ASSESSMENT REPORT

Sydney Southwest Private Hospital MP 10_0091 MOD 2

This report is an assessment of a request to modify the Major Project Approval (MP 10_0091) for the construction of a four-storey extension to the existing Sydney Southwest Private Hospital (SSPH) at 24-40 Bigge Street, Liverpool.

DRAWING TITLE:
LEVEL BASEMENT

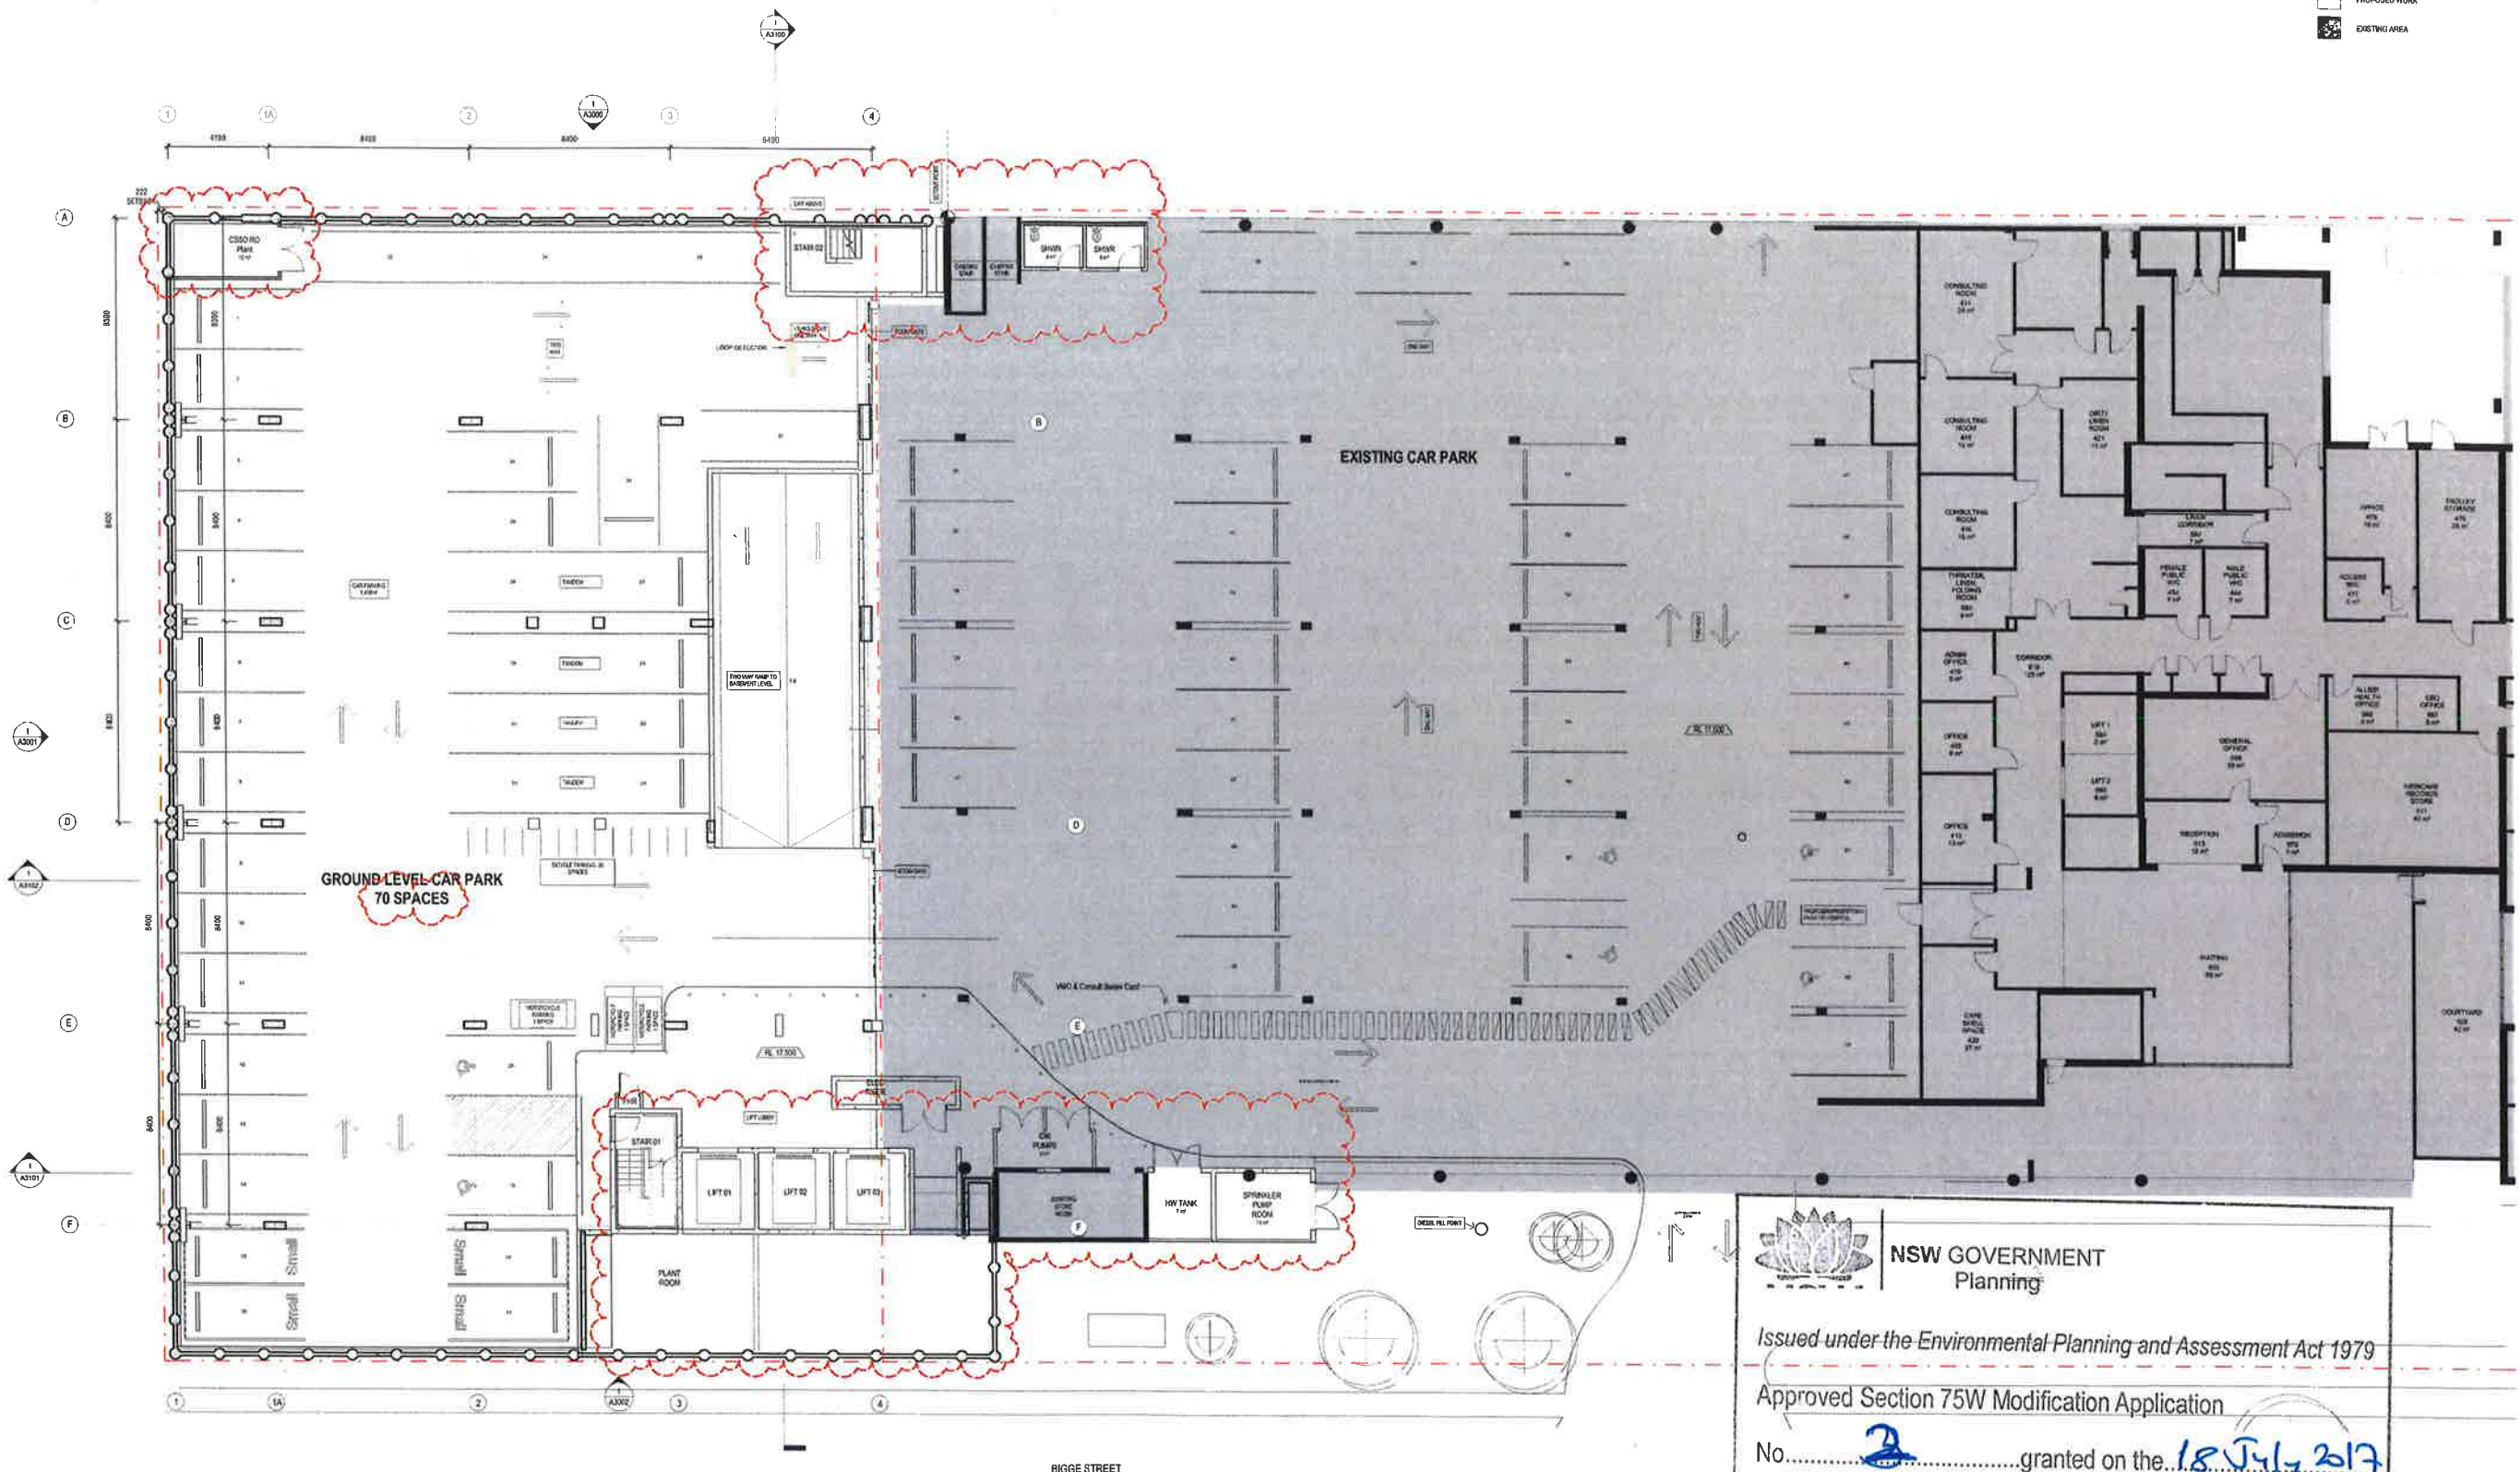
<i>Car Parking</i>	<ul style="list-style-type: none"> The proposal will result in the removal of five car spaces, including: <ul style="list-style-type: none"> three car spaces in the basement; one car space at Level 00; and one car space in the outdoor parking area.
<i>Staging of Construction</i>	<p>The proposal seeks to construct the hospital extension in three stages, as follows:</p> <p><i>Stage 1</i></p> <ul style="list-style-type: none"> construction of the basement to Level 4; installation of temporary roof and plant; fit-out at Levels 1 and 3; <p><i>Stage 2</i></p> <ul style="list-style-type: none"> fit-out at Level 2 <p><i>Stage 3</i></p> <ul style="list-style-type: none"> construction of Level 5 and 6 roof structures; amend layout at Level 1; fit-out at Level 4; roof plant at Level 5; lift overrun and roof structure at Level 6;

<i>Parking and Traffic</i>	<ul style="list-style-type: none"> The Department noted a discrepancy between the number of car parking spaces approved in Modification 1 and proposed in Modification 2 and requested the Proponent to clarify car parking provision on the site. The Proponent confirmed: <ul style="list-style-type: none"> The traffic report accompanying Modification 1 stated that 122 car spaces were provided. However, a review of this application indicates 140 spaces were shown on the plans. The current modification would reduce car parking by three spaces from 140 to 137. Council raised concern about the loss of car parking on the site and recommended a condition be imposed requiring payment of contributions for any shortfall in car parking. The Liverpool Development Control Plan 2008 (DCP 2008), requires one car space per 100 sqm of floor area for hospitals. The SWPH has a total floor area of 12,215 sqm and would therefore require 122 spaces. The development proposes a total of 137 car parking spaces, which is 15 spaces more than required under DCP 2008. The Department is therefore satisfied the proposal would continue to comply with Council's car parking controls and as such, there is no need to pay contributions for car parking. 	No additional conditions or amendments necessary.

DRAWING TITLE:
LEVEL 01

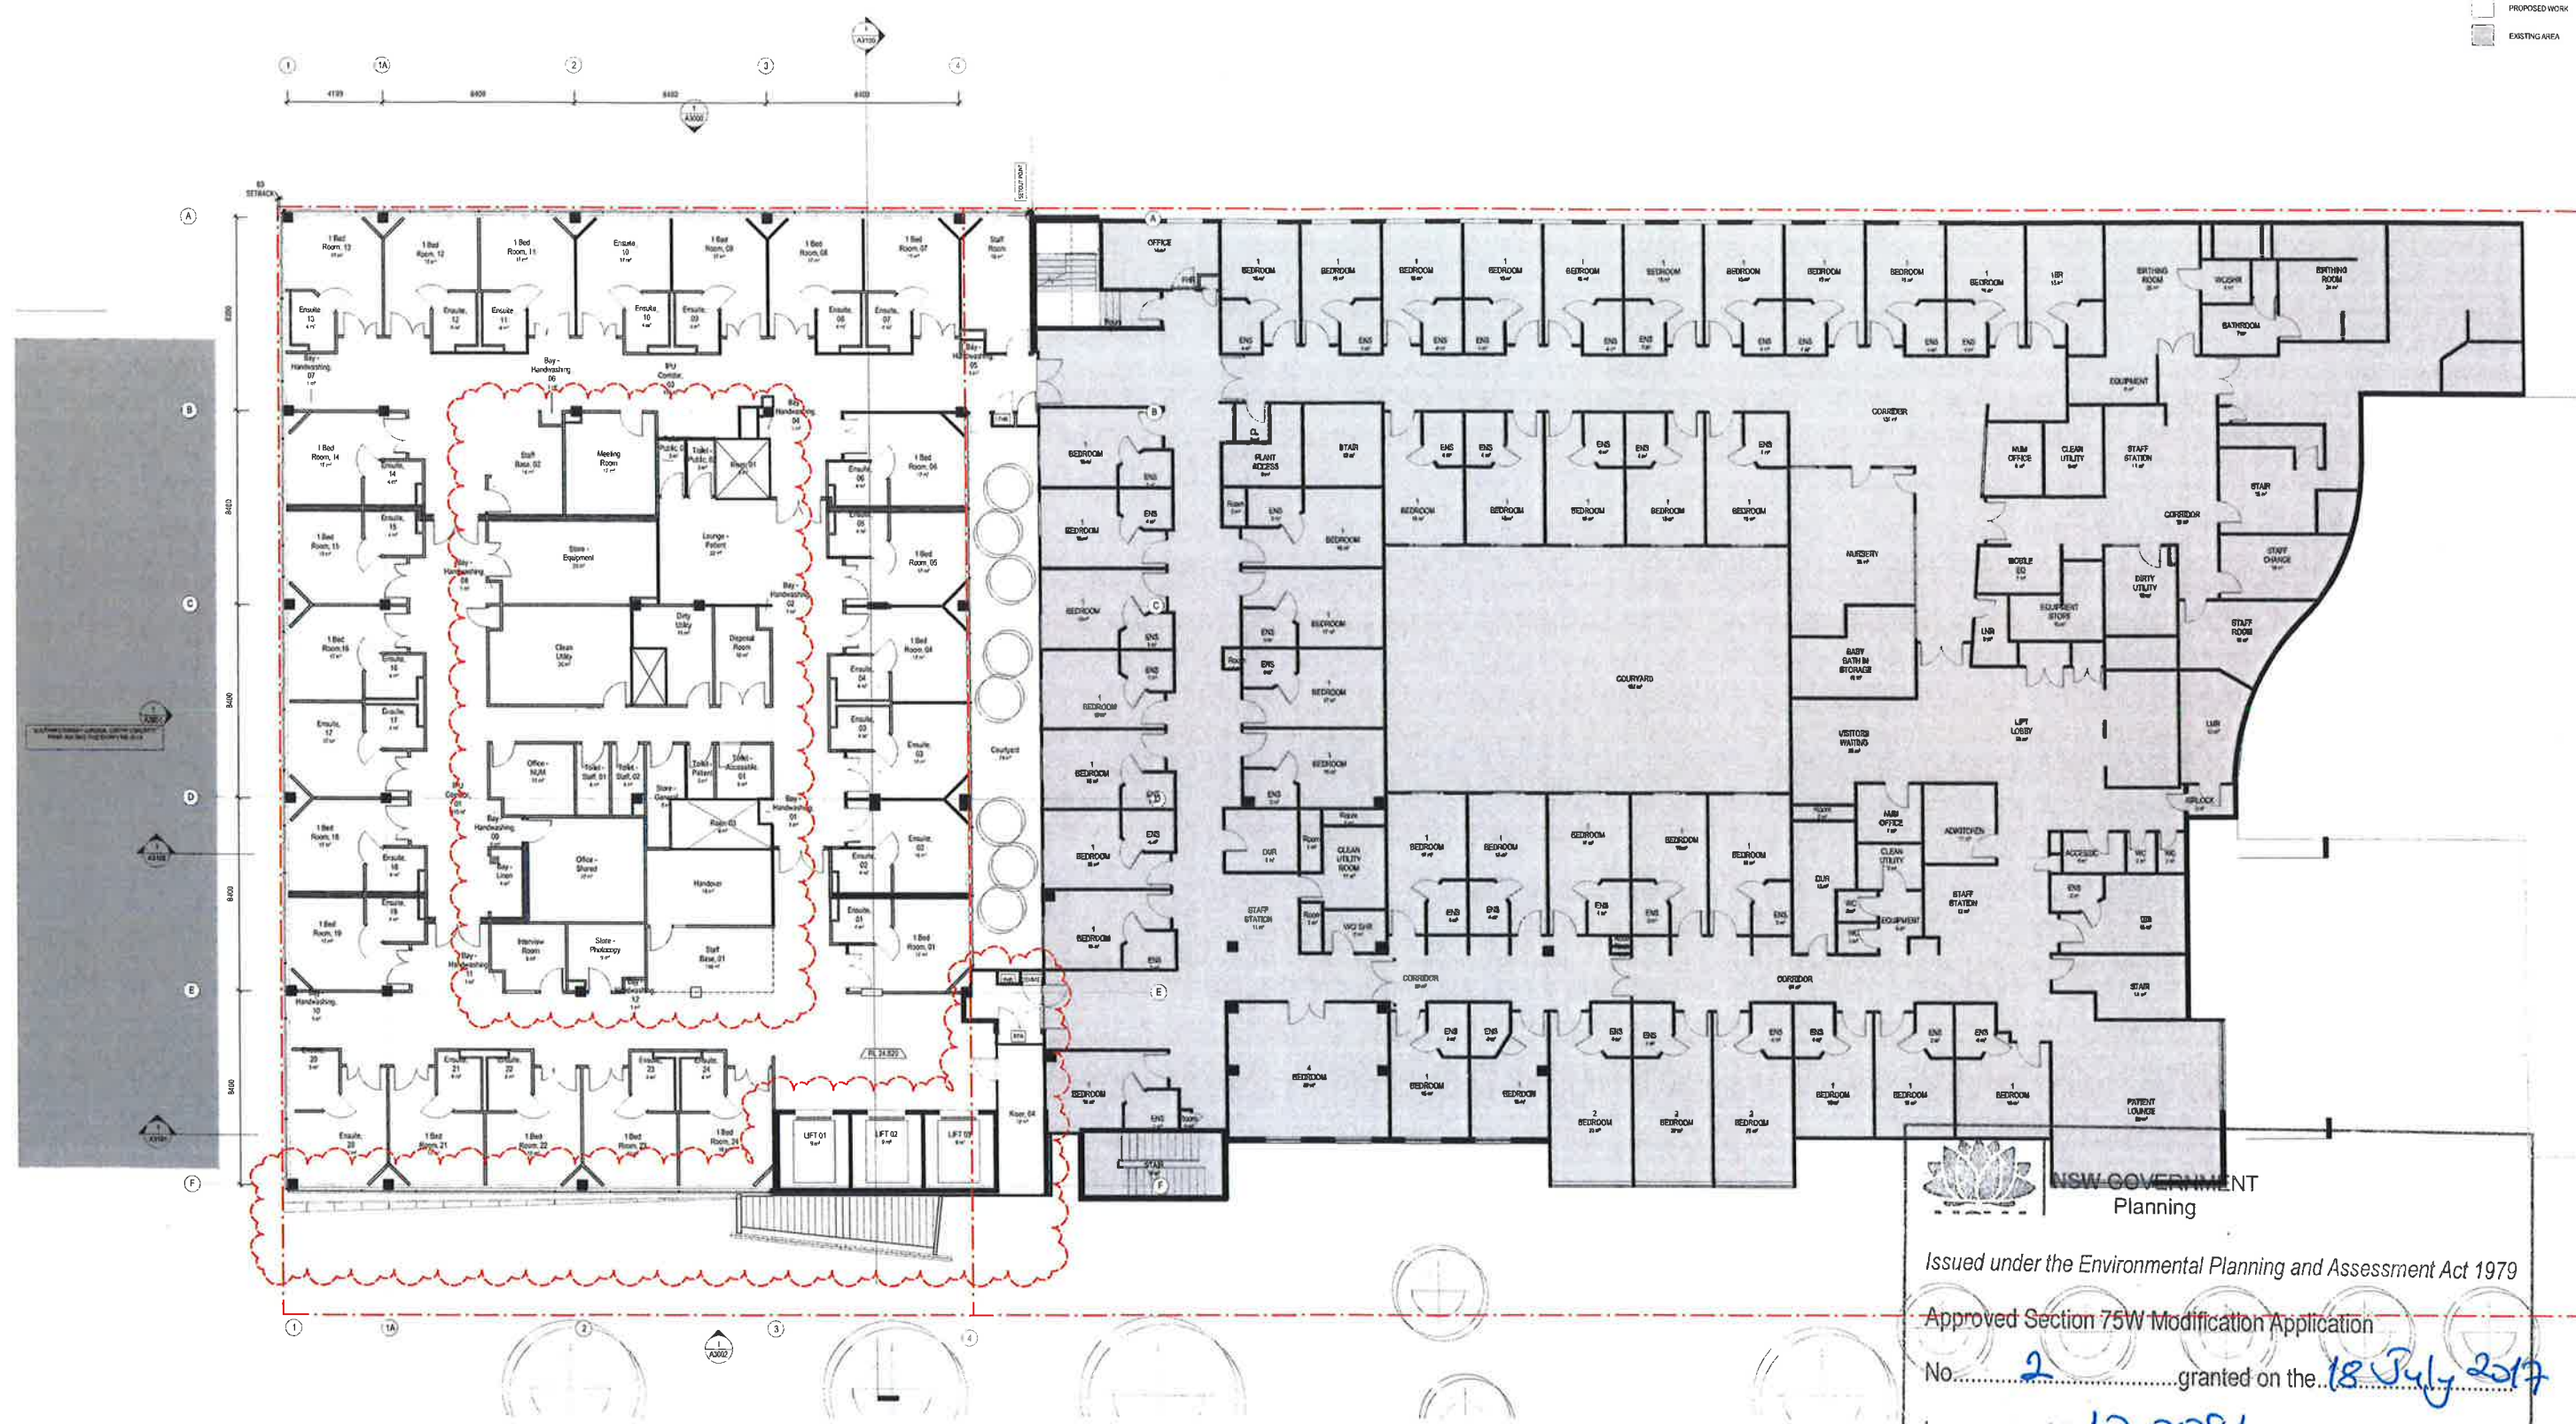
Proposed Modification	
External Design Changes	<p>The key changes to the external design include:</p> <ul style="list-style-type: none">• an increased building setback to Bigge Street by 83 mm;• an increased building height by 2.35 m to accommodate the lift overrun, lift motor and roof structure;• amendments to the plant layout and screening and metal roof deck;• revised materials and finishes; and• installation of an oxygen tank in the outdoor car park.
Internal Design Changes	<p>The key internal changes include:</p> <ul style="list-style-type: none">• reconfiguration of the fire stairs and risers at each level;• provision of a new power supply and main switch room in basement;• a new store room, showers and plant room at ground level;• replacement of five consulting suites with three operating theatres and support spaces at Level 1; and• reduce the total GFA from 12,245sqm to 12,215sqm.

DRAWING TITLE:
LEVEL 06 ROOF

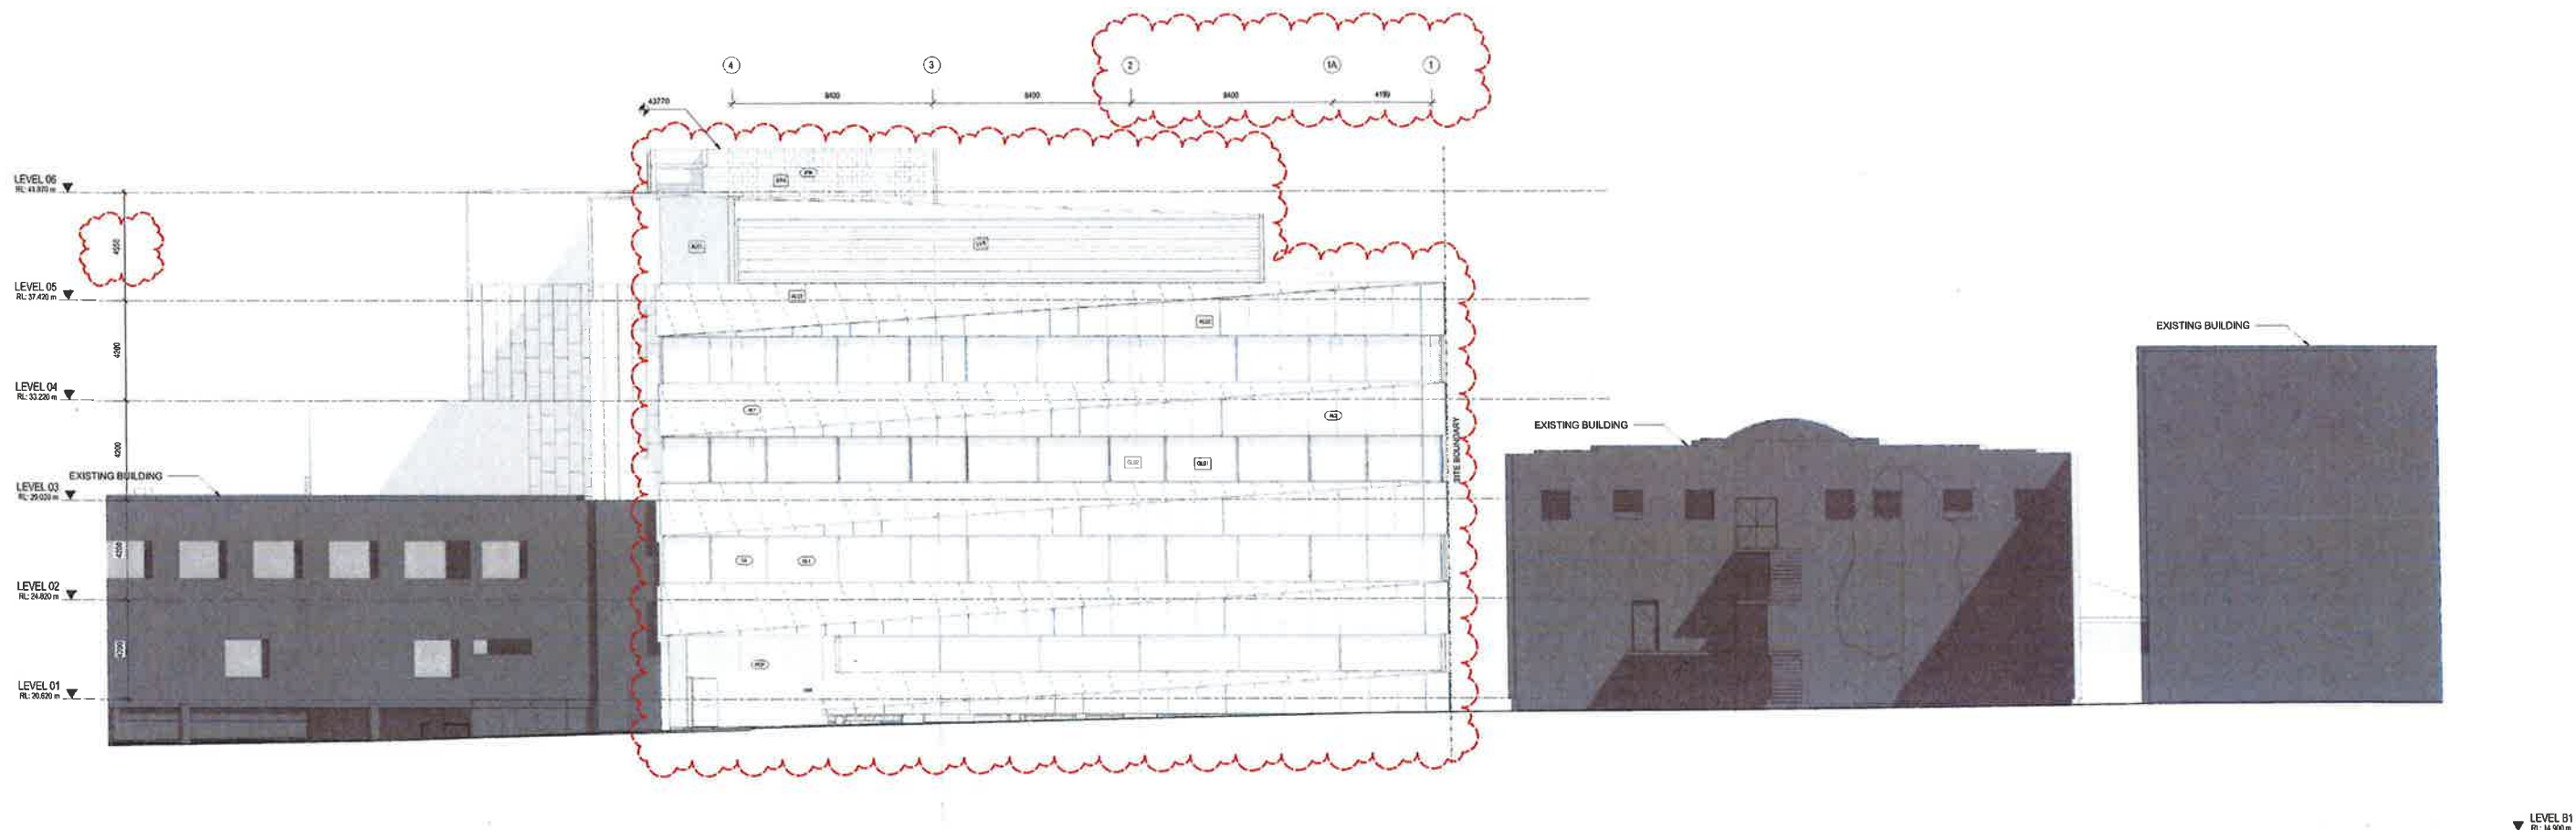
<i>Acoustic Impacts (mechanical plant)</i>	<ul style="list-style-type: none"> • The Proponent submitted an Acoustic Report to assess the potential noise impacts associated with the roof top plant. • The Applicant's Acoustic Report advises the mechanical plant can be treated to mitigate any potential noise impacts. • The Department notes the existing conditions of approval include strict noise conditions which require: <ul style="list-style-type: none"> – an acoustic engineer to confirm the mechanical systems comply with the relevant Council requirements and Australian Standards; and – noise associated with the operation of any plant, to comply with relevant noise criteria and not to be audible in residential properties between 12.00 midnight and 7.00am. • The Department is therefore satisfied there are appropriate safeguards in place to mitigate any potential noise emanating from the mechanical plant. 	No additional conditions or amendments necessary.
